Bladon Parish Council

Bladon Parish Council (BPC) wishes to submit the following comments for Deadline 3.

BPC Comments on Applicant's Response to ExA First Written Questions

Botley West Solar Farm  
 Historic and Scheduled Sites Plan  
 Sheet 9 of 24

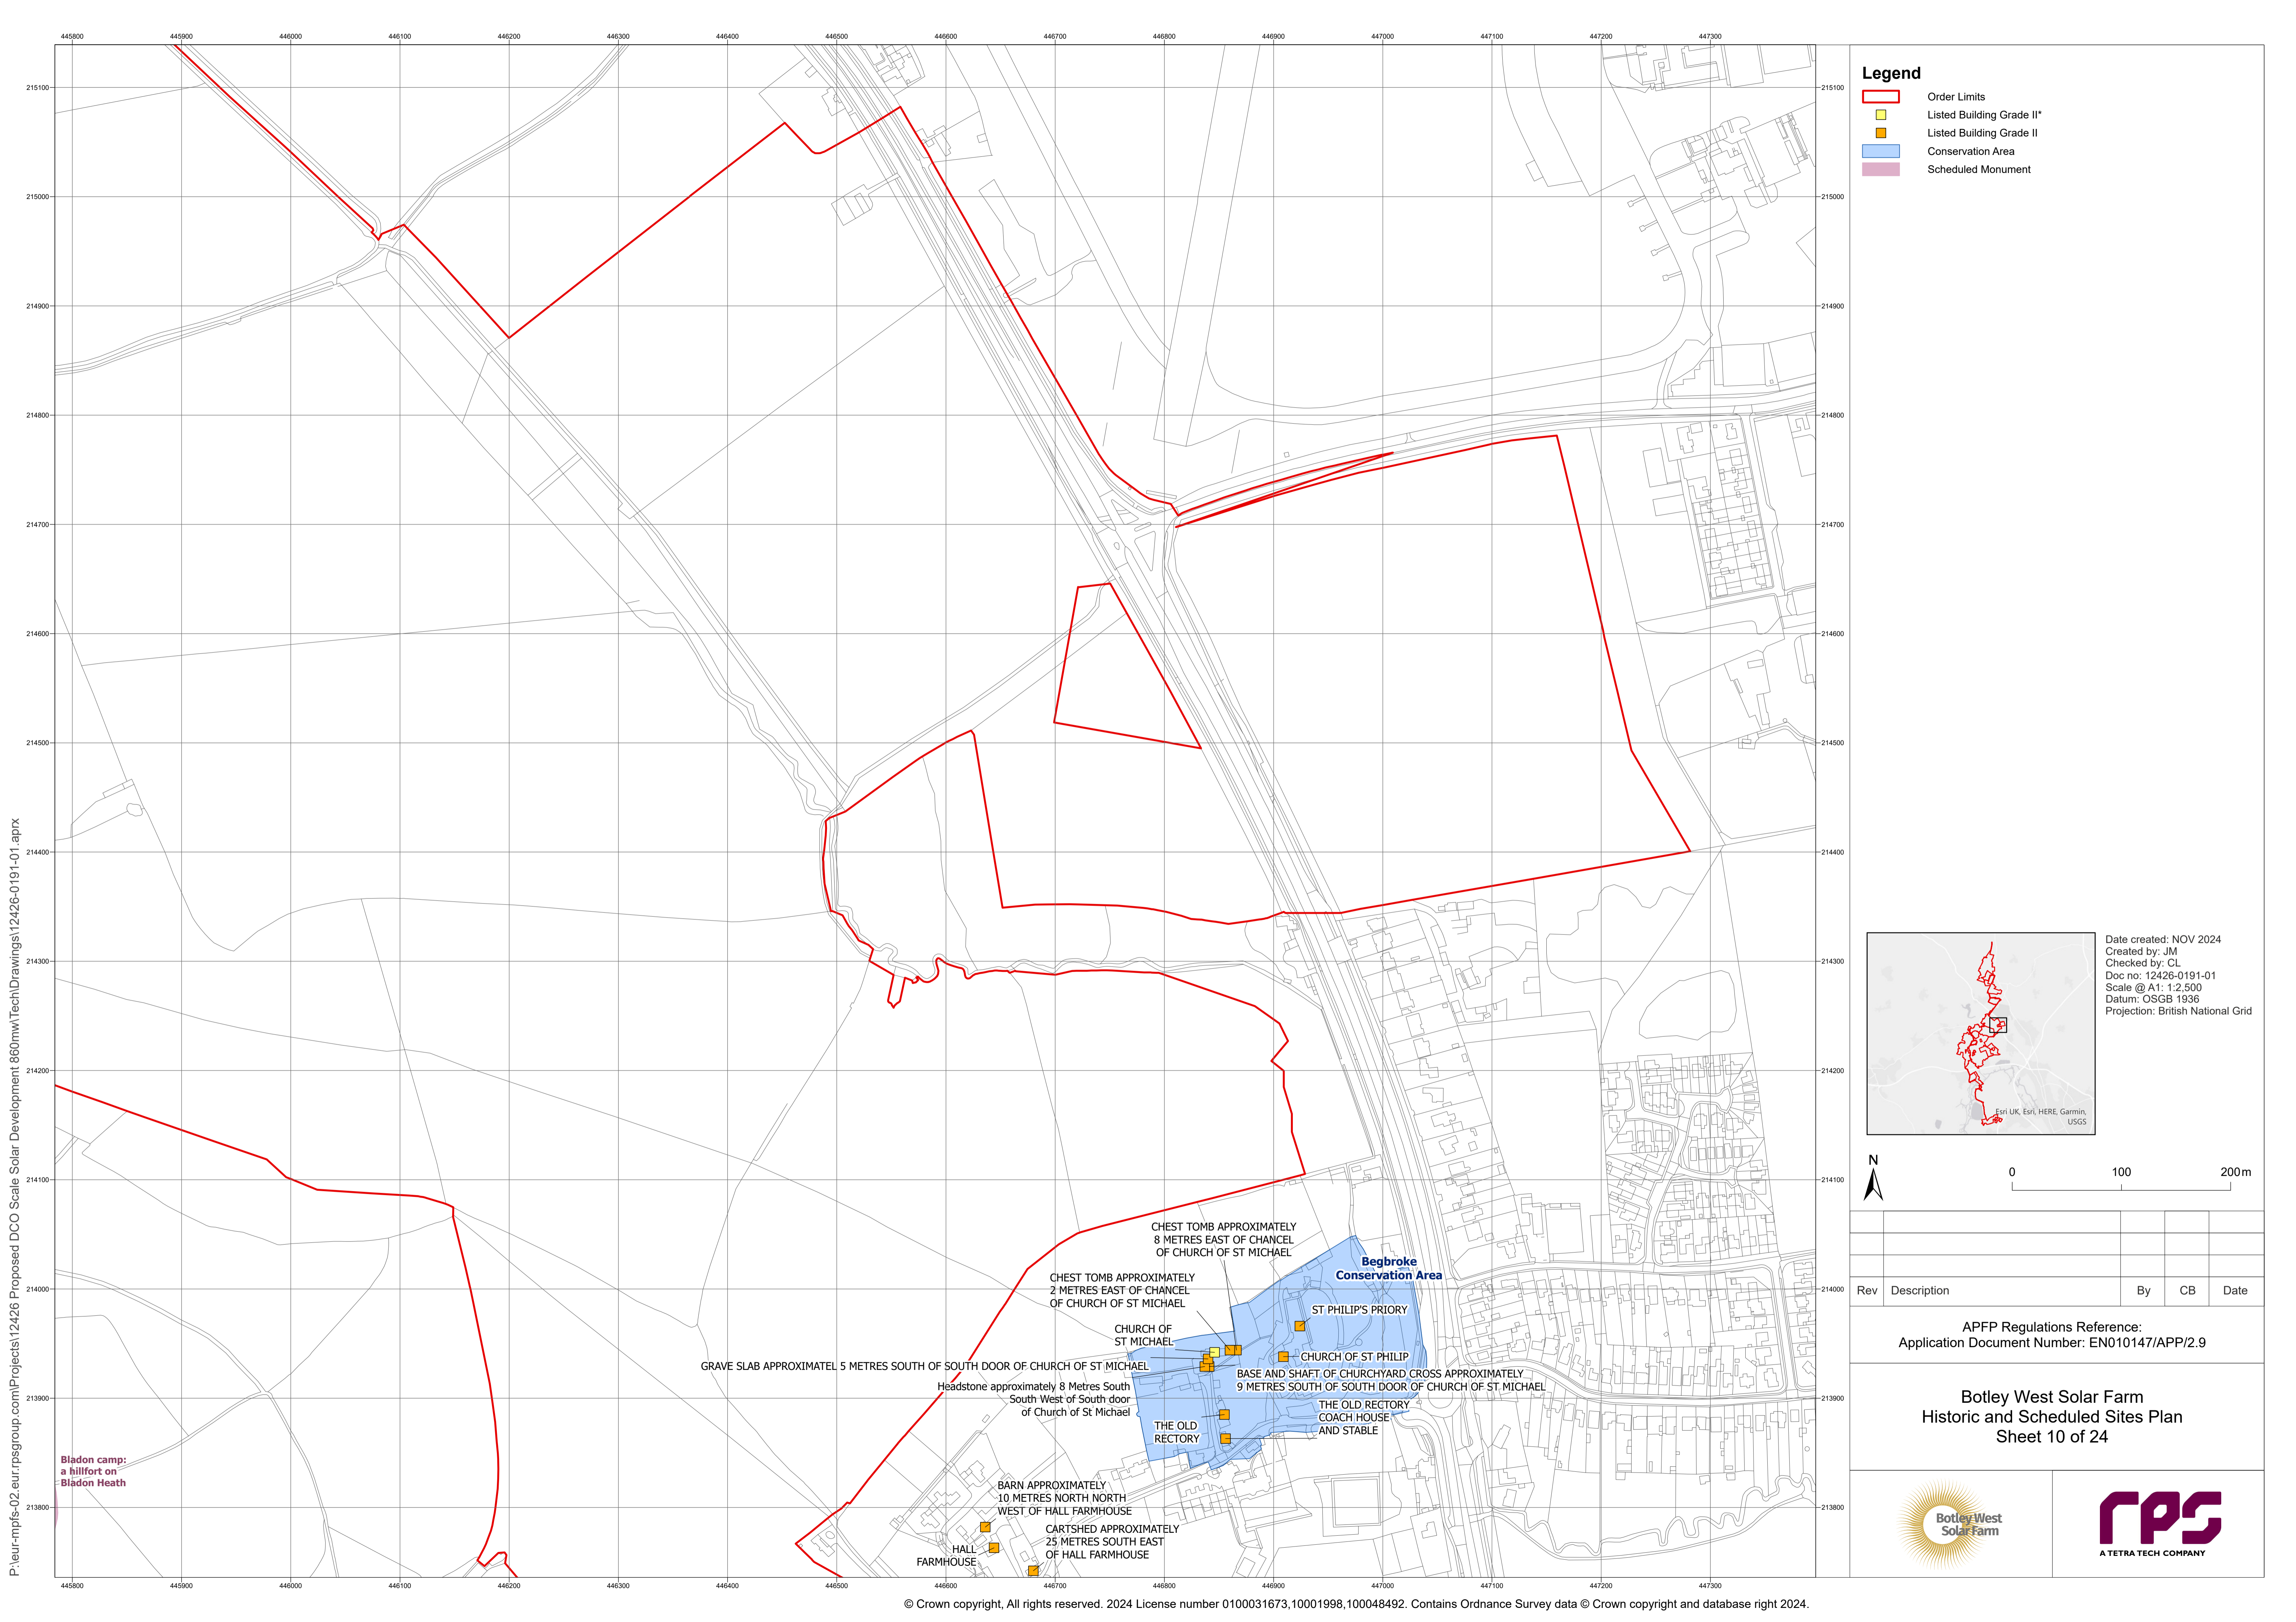
It has come to BPC's attention that PRoW 132/4/10 would require permanent stopping up and diversion during construction and operation of the Project.

This is a beautiful and historic route, a mediaeval road from the top of Heath Lane across three large fields to Begbroke. It is widely used by walkers not only from Bladon but further afield, and BPC believe that to lose this PRoW would be a severe detriment both to Bladon and Begbroke Parishes.

- Land Available for Educational Area [Yellow diagonal lines]

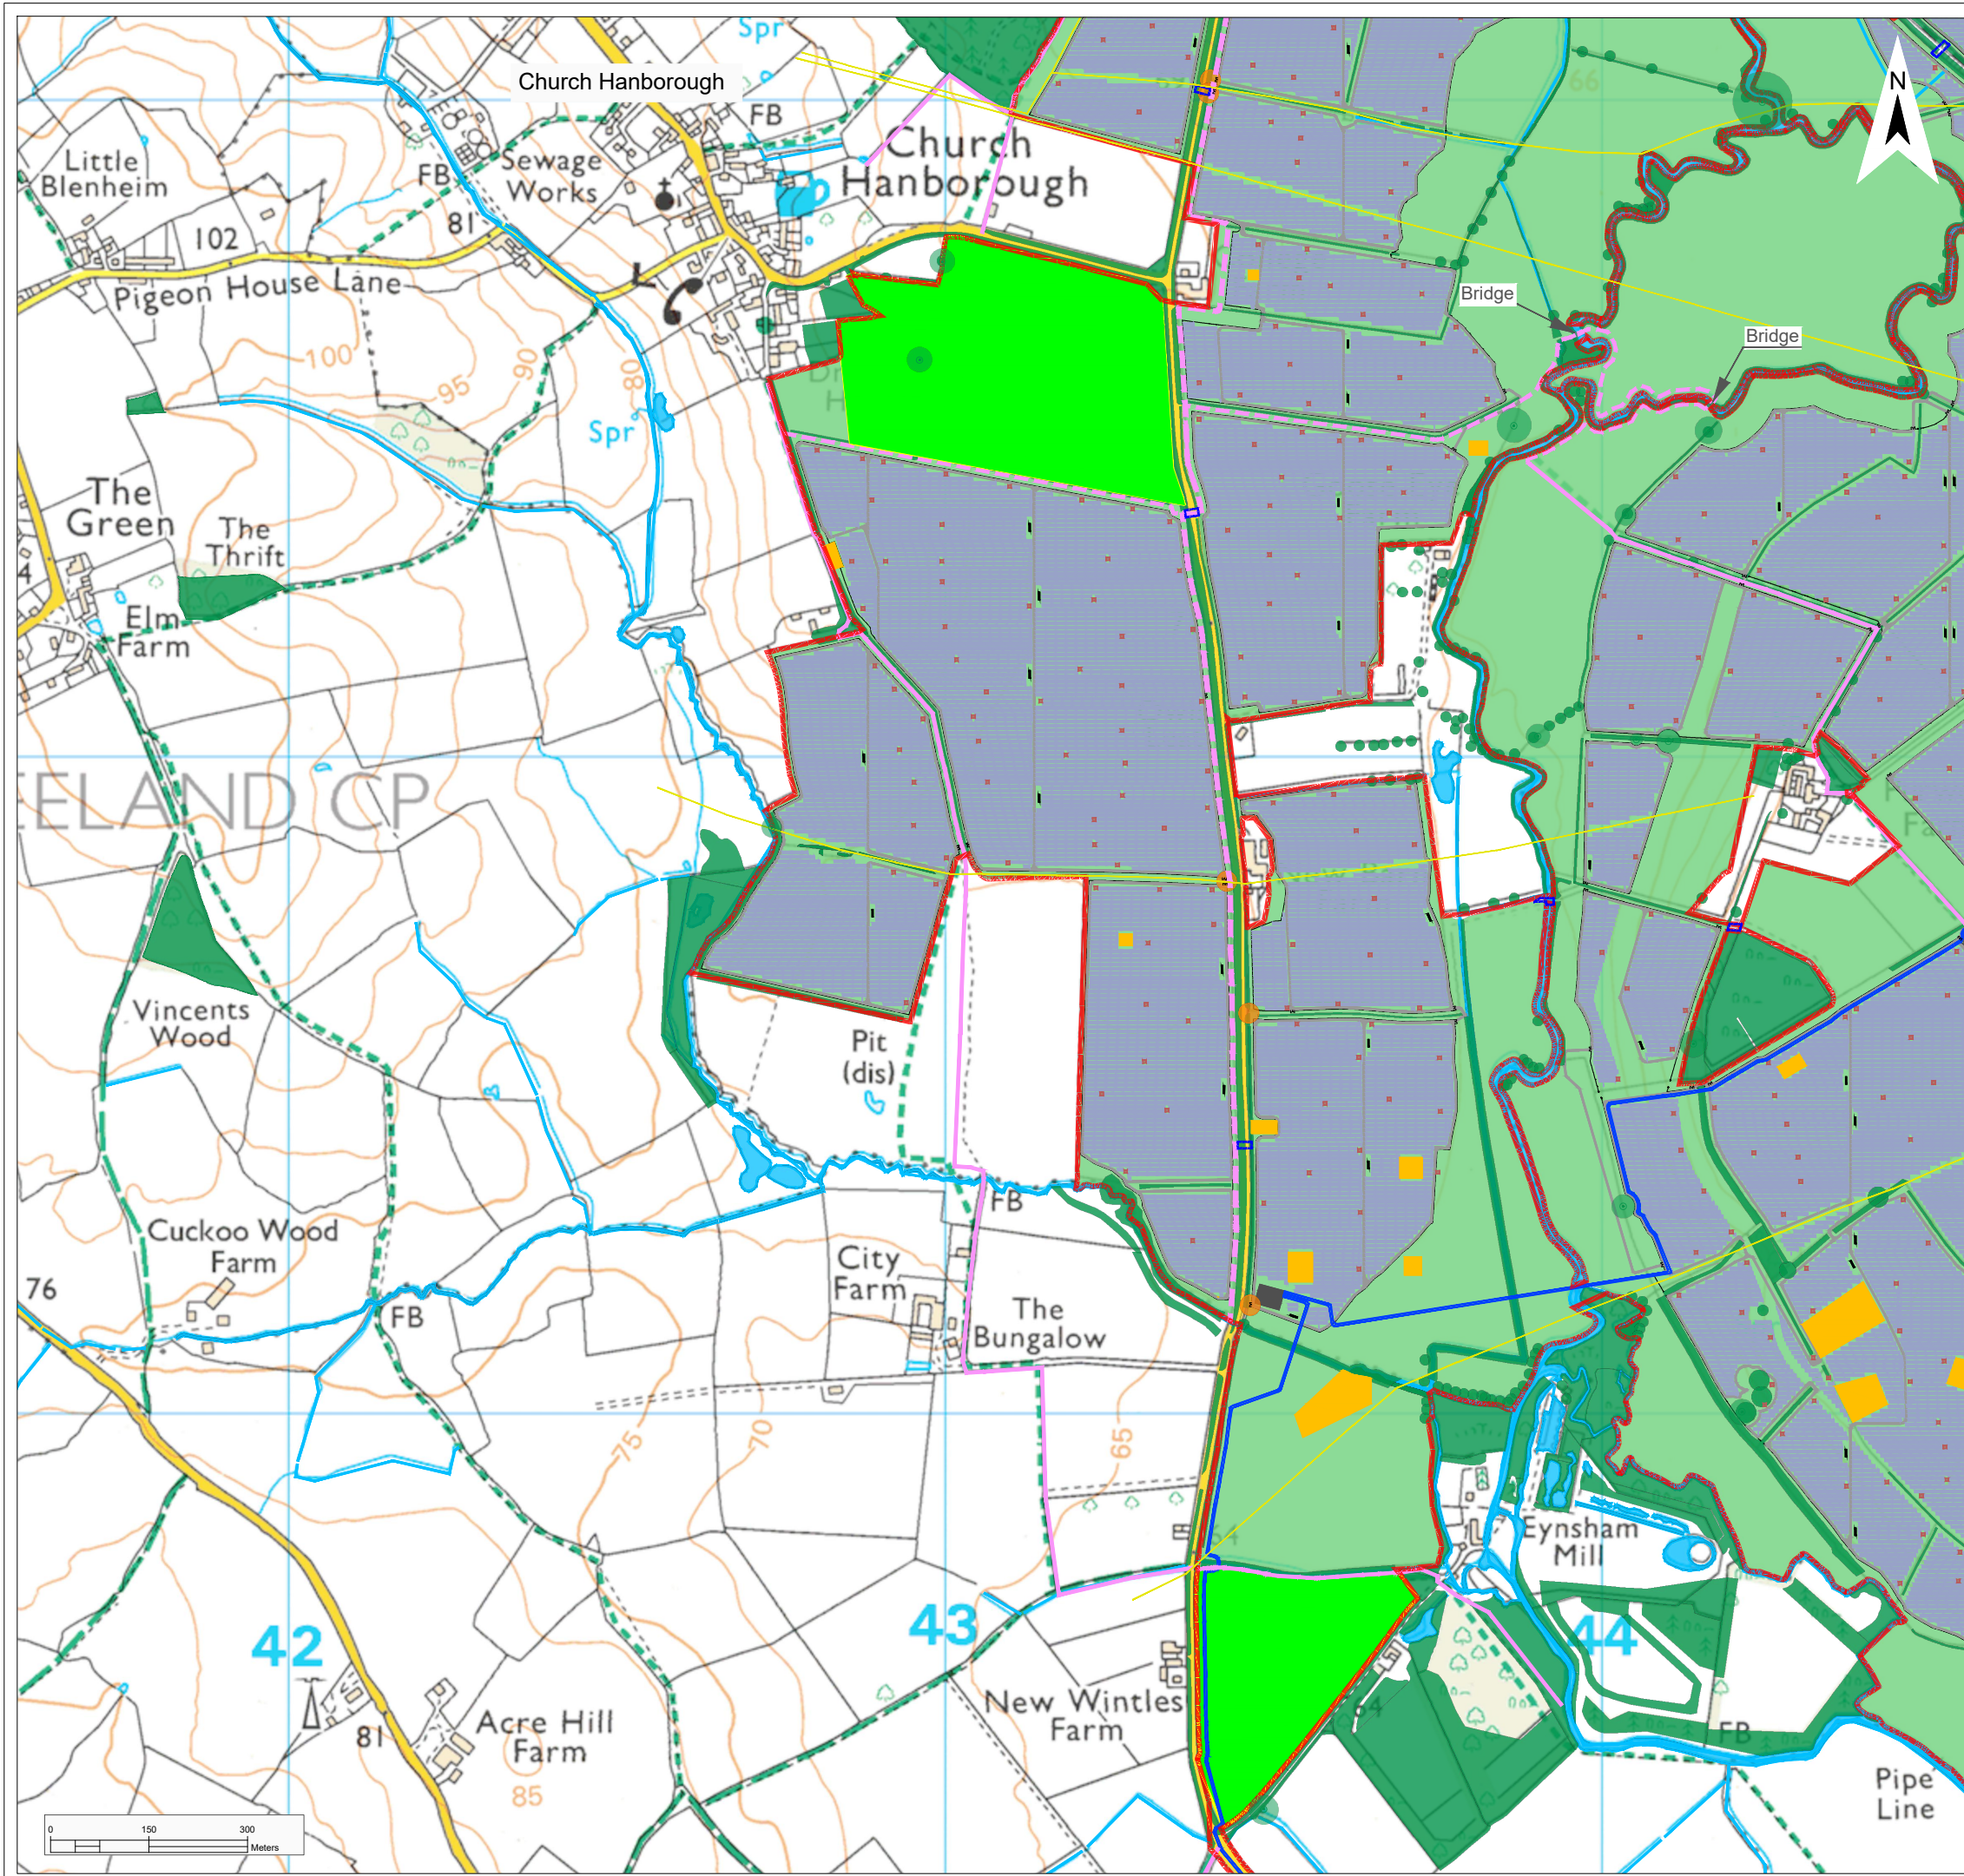
<p>Q1.16.21 Applicant Education facility building</p>
<p>ExA Question</p>	<p>Please confirm how the possible location for the education facility was selected? What level of consultation was undertaken with local stakeholders in respect of the possible location? The Outline Operational Management Plan [APP-234] confirms that further detail in respect of the education facility is to be set out in the detailed Operational Management Plan. Please confirm why such detail is to be confirmed post-consent, rather than during the Examination. The Project Mitigation Measures and Commitments Schedule [APP-129] states that the provision of such an education facility to be additional mitigation. Given that limited information has been provided in respect of this facility, please confirm what weight should be given to this by the ExA.</p>
<p>Applicant's Response</p>	<p>Through discussions with the OCC team, an Education Facility was identified as an opportunity. Chapter 16 [APP-053] paragraph 16.9.133 includes the statement;</p> <p><i>“Provide open and covered space in the solar farm for use by school field trips. An educational area could provide local schools with the basic facilities – benches and a covered area to undertake their own learning activities. Potential to walk to the educational site and potential for guided access to array areas would support both physical activity and learning outcomes for population health. Indicative layout (as set out with Outline Operational Management Plan [EN010147/APP/7.6.2]) includes toilet (compost) and minibus parking (either provided or existing). Secured as a requirement of the DCO - via oOMP [EN010147/APP/7.6.2].</i></p> <p><i>Location, size and scale will be finalised during detailed design phase and included within the detailed Operational Management Plan. The educational area is illustratively shown in Figure 16.2: Illustrative 3D Views of Educational Facility [EN010147/APP/6.4]. The expectation is that there will be post consent</i></p>

<p><u><i>community involvement in the refinement of design and selection of an appropriate location.</i></u></p> <p>A potential location was identified to the east of Bladon, on land adjoining existing community facilities (land next to a playground, MUGA, and allotments) and where there is a suitable vehicular and pedestrian access, which also serves the Bladon Primary School and the Parish church.</p> <p>In order to take this proposal forward, and to allow it to be considered as additional mitigation, it is now intended to develop the proposals through the submission of a formal Change Request. This is reflected in Change Request Notification 2, as submitted at Deadline 2.</p>
BPC Comment	<p>BPC would like to inform the ExA that the Parish Council has not been consulted regarding the proposed location of this facility.</p> <p>Had BPC been consulted, then the council would have raised concerns with the applicant about the current access route to the suggested location and the negative impacts a facility at this location may have on the community.</p> <p>The access road is limited to single-file traffic and does not have designated passing points. Additionally, a pinch point at the entrance further restricts the width, rendering the road inaccessible to vehicles such as ambulances and skip lorries. There has been an instance in which a resident required transport to an ambulance stationed on the main road due to these constraints.</p> <p>The use of this road as the main access point for either the educational facilities or the proposed community food growing area on the opposite side raises significant safety concerns for pedestrians. This route serves not only as the primary walking path to the recreation ground, allotments, cemetery, and St Mary's Church, including the grave of Sir Winston Churchill, but is also used daily by students and parents to access the only entrance to Bladon Primary School. Additionally, the school regularly utilises the recreation ground for physical education lessons, requiring groups of children to walk between the school and the recreation ground on a regular basis.</p> <p>Furthermore, visibility when entering the lane from the main road is limited, increasing the risk of vehicles encountering each other head-on and requiring one party to reverse onto the main road or another wider section, which presents additional safety concerns.</p> <p>BPC would like to understand the reasoning behind selecting Bladon as the location for a facility that does not appear to offer direct benefits to Bladon residents. BPC believes that any potential advantages for residents are likely to be outweighed by adverse effects on the village, including increased traffic and visitor numbers that will be using an access road that is already known to present challenges, as well as the potential disruption to the peaceful environment enjoyed by individuals walking along PRoW 132/2/10.</p> <p>BPC believes that there are other locations which would be more easily accessible, such as directly off Lower Road or A4260 North of Woodstock or a location in the Southern area and also would a location that is not within the Green Belt.</p>
